From: Anthony.Collier@hertfordshire.gov.uk
Sent: 26 September 2016 15:07
To: Planning
Subject: Planning application 6/2016/1778/FULL - 11 Brookmans Avenue

Response to Planning application from Hertfordshire County Council (T and CP GDP Order 2015)

District ref: 6/2016/1778/FULL
HCC ref: WH/188/2016
HCC received: 22/09/2016
Area manager: Manjinder Sehmi
Case officer: Anthony Collier

Erection of replacement building containing 5 flats with forecourt parking following demolition of existing house

Drawing Title
 PROPOSED SITE PLAN AND
 STREET SCENE

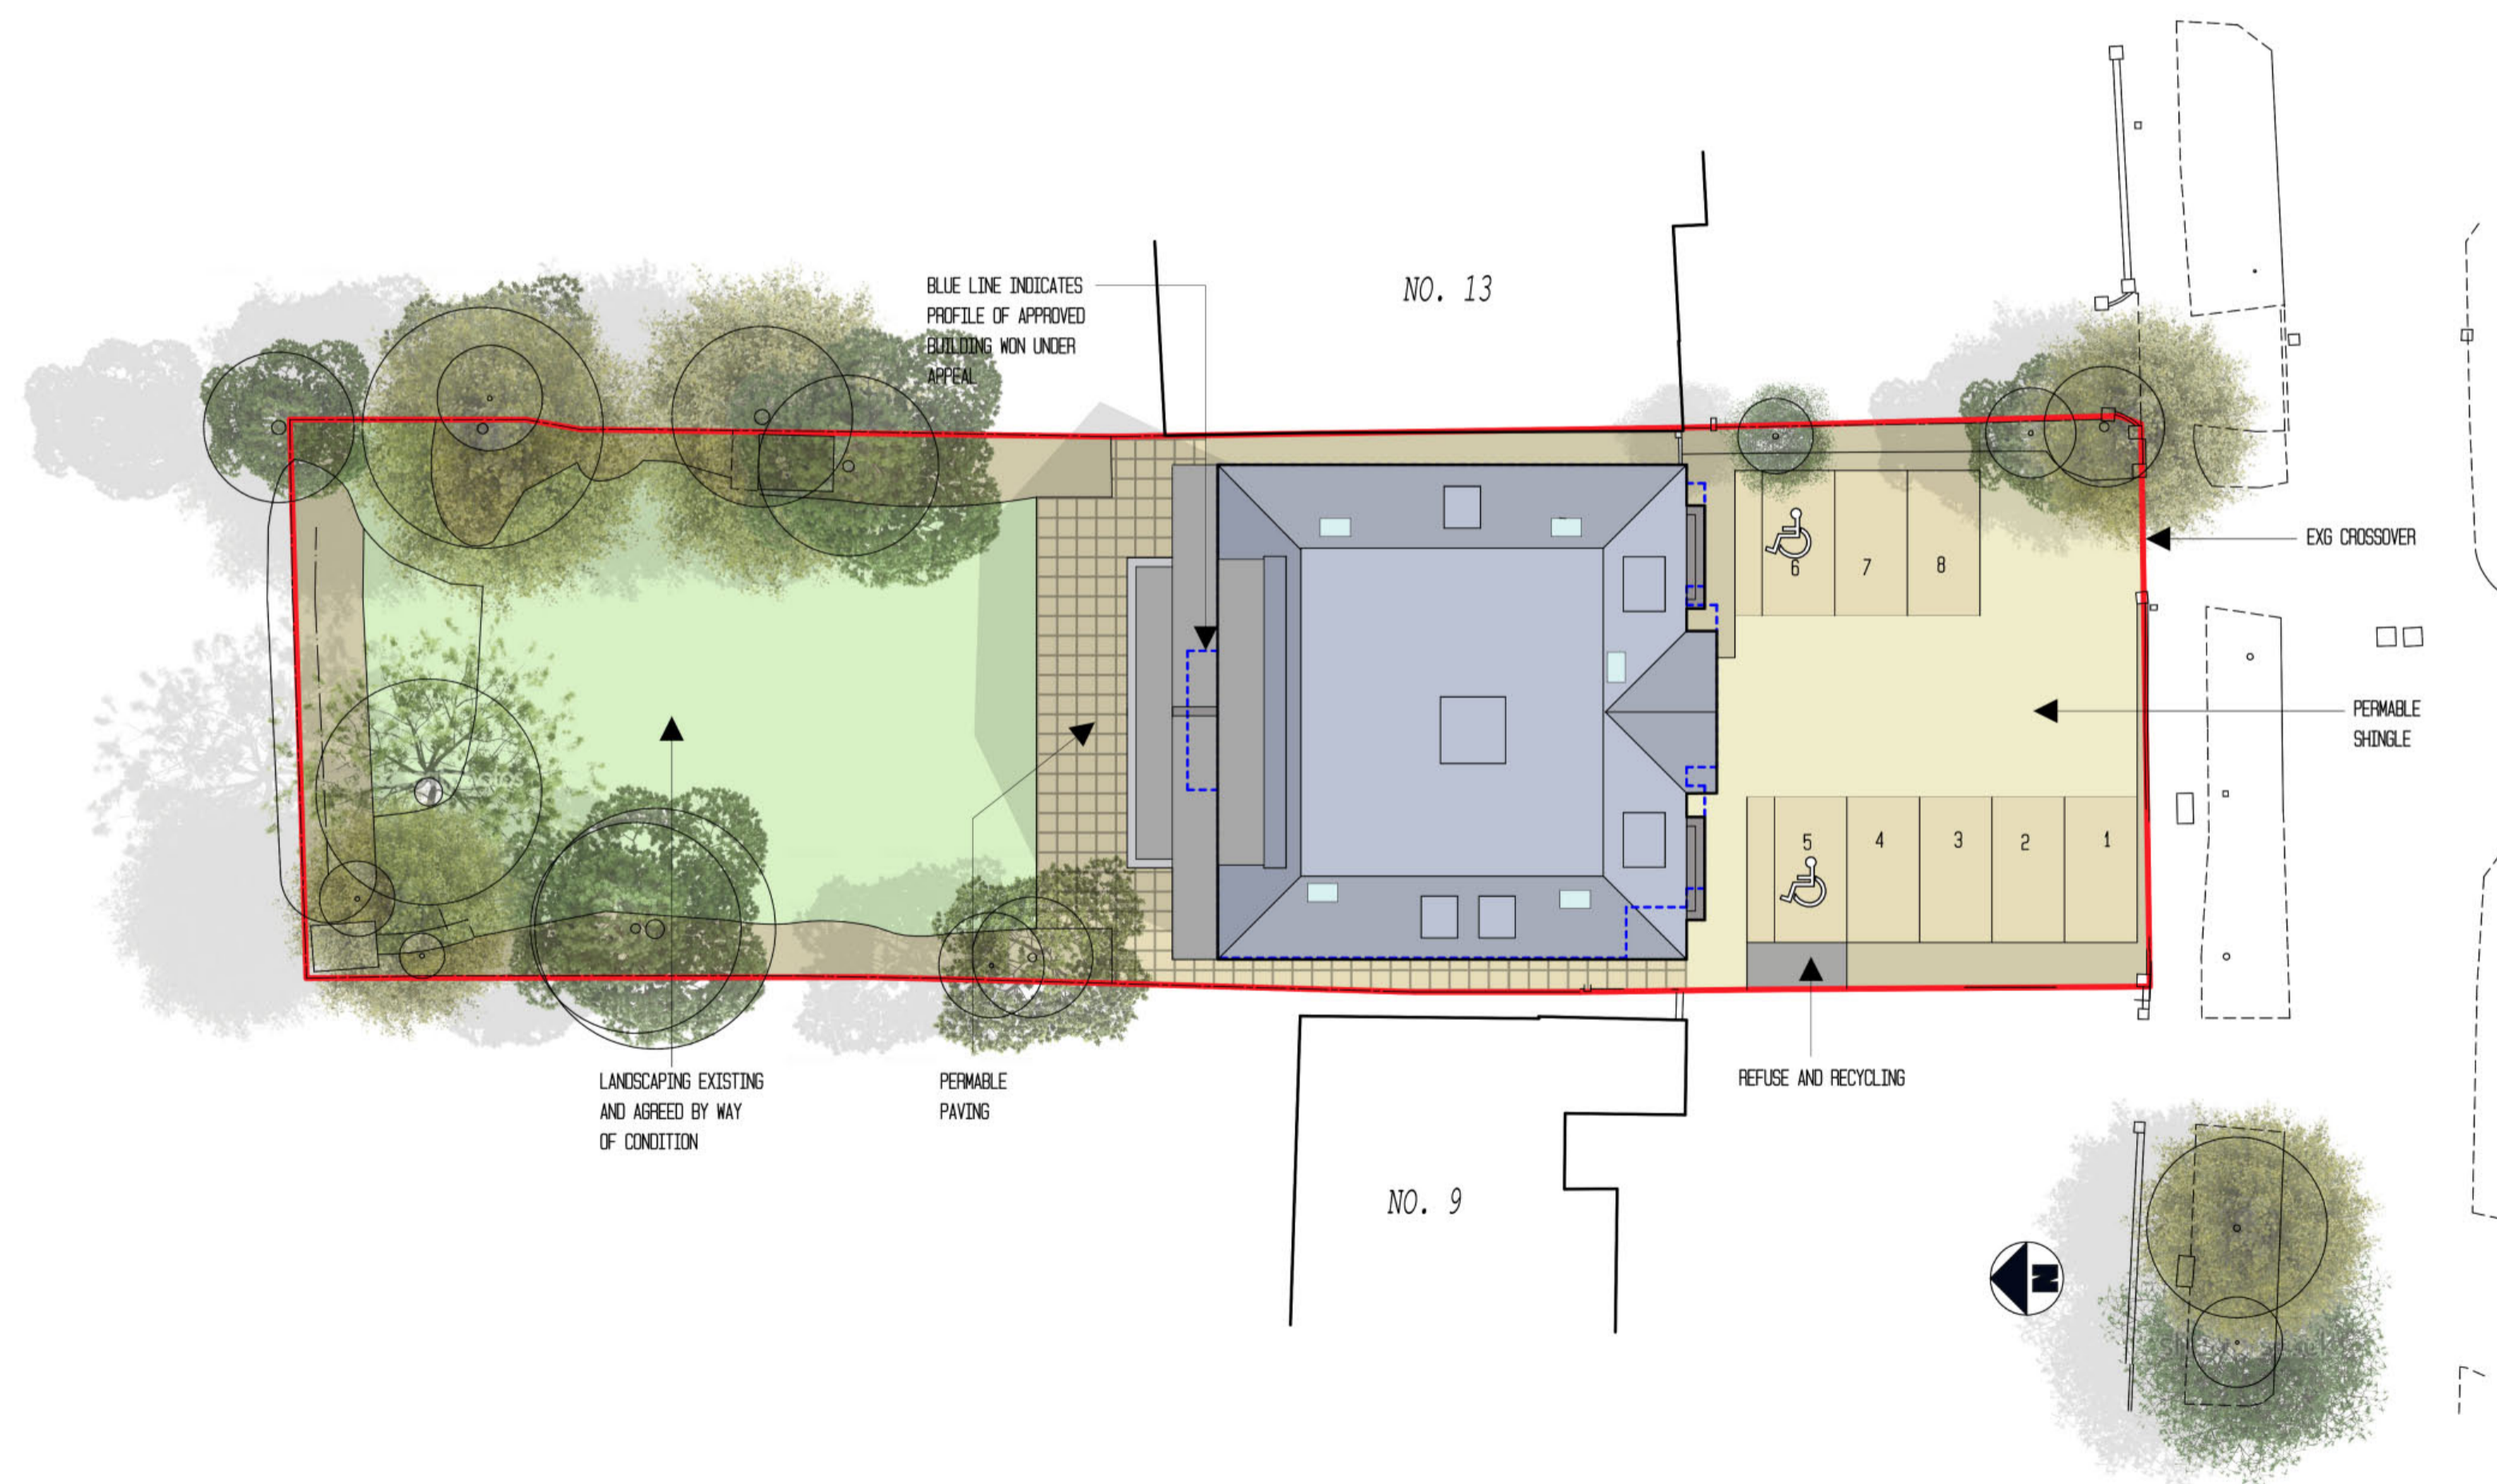
The new proposal appears to remove an existing vehicle cross over onto Brookman's Avenue. The proposals use the one of the existing access arrangements without amendment, and provide a carriage driveway arrangement to the dwellings. The development proposes 8 parking spaces within the frontage, with appropriate depth behind each space to enable vehicles to access these spaces without undue difficulty. The arrangement enables all vehicles leaving to do so in forward gear and with adequate sight lines from the access. It is advised that the LPA review adequacy of provision. The LPA shall clearly assess the proposals against their own Parking Standards.

The driveway is shown as being laid to permeable shingle whereas at present it is to hard standing. The provision of a permeable surface will reduce surface water run off, particularly given the large area given over to parking, however the creation of a surface of a loose shingle material shall result in this loose material being tracked into the footway and carriageway. Such material shall be prejudicial to the safety of pedestrians / road users, particularly cyclists and motorists as well as vulnerable pedestrians (elderly/ mobility impaired / persons with prams / buggies). I would recommend that any grant of consent includes, in the interest of public safety, that a bound material is used for the driveway surfacing.

- 1) The parking area hereby permitted shall be surfaced in tarmacadam or similar durable, bound material, and be completed before first use of the development. Arrangements shall be made for surface water from the site to be intercepted and disposed of separately so that it does not discharge into the highway. Reason: To avoid the carriage of extraneous material or surface water from the site into the highway so as to safeguard the interest of highway safety.
- 2) Prior to the first occupation of the development hereby permitted the proposed on-site vehicle Parking shall be laid out, demarcated, levelled, surfaced and drained in accordance with the approved plan and retained thereafter available for that specific use. Reason: To ensure the permanent availability of the parking /manoeuvring area, in the interests of highway safety.
